# CITY OF PORTLAND BUILDING PERMIT

**PERMIT ID:** 2013-01806

has permission to **Add exterior ramp and modify width of 3 doors.**

**FLOOR PLAN DEMOLITION PLAN**

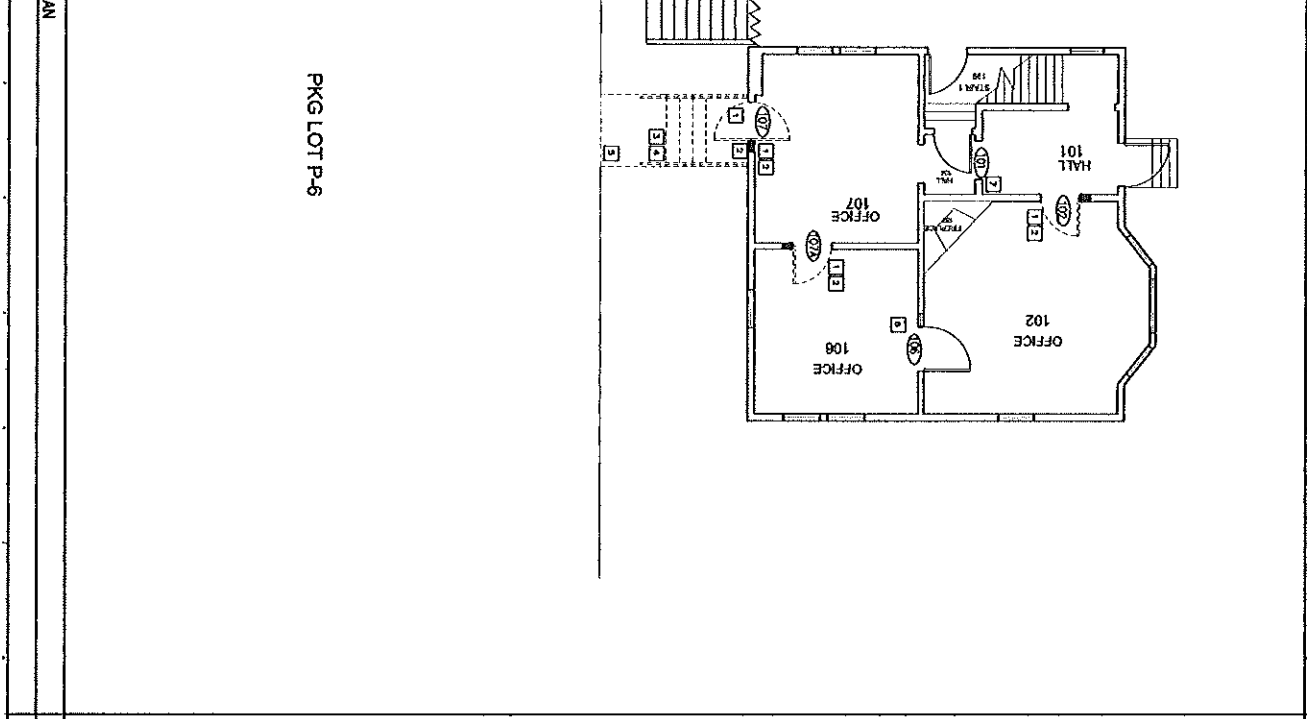
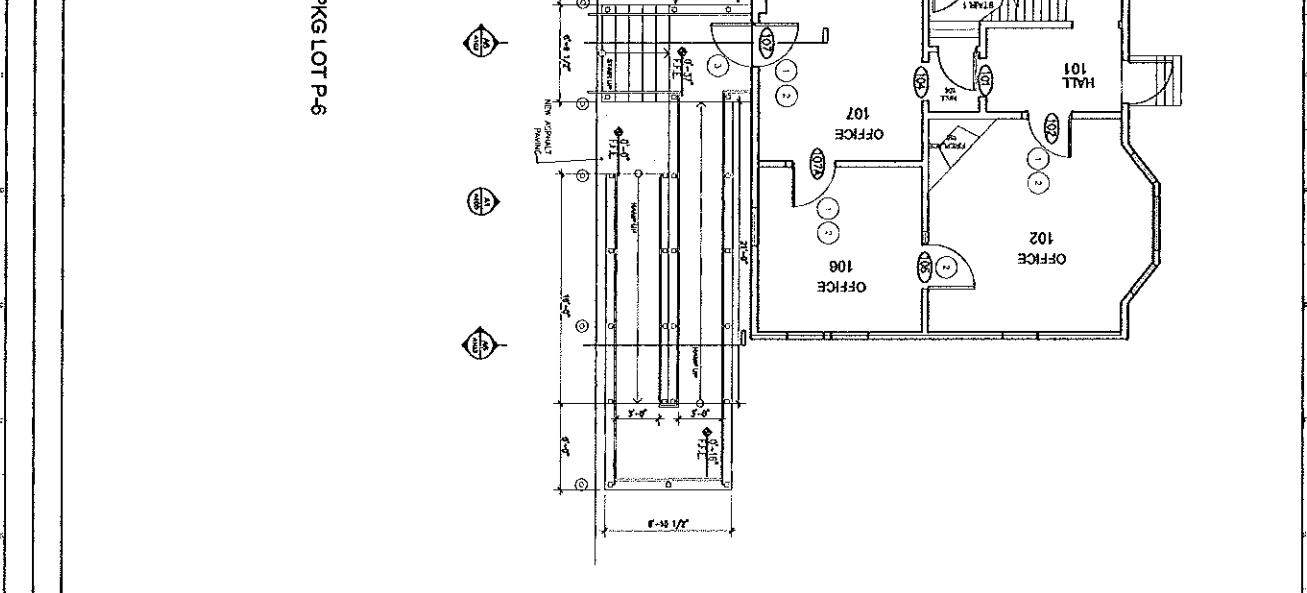
1) This work requires a site plan review (probably an Administrative Authorization) thru the Planning Division.				
2) All required setbacks are to property lines. 8' minimum required where 15' shown on recently submitted plans.				
<hr/>				
<b>Dept:</b> Building	<b>Status:</b> Approved w/Conditions	<b>Reviewer:</b> Jeanie Bourke	<b>Approval Date:</b> 09/13/2013	
<b>Note:</b>	<b>Ok to Issue:</b> <input checked="" type="checkbox"/>			
<b>Conditions:</b>
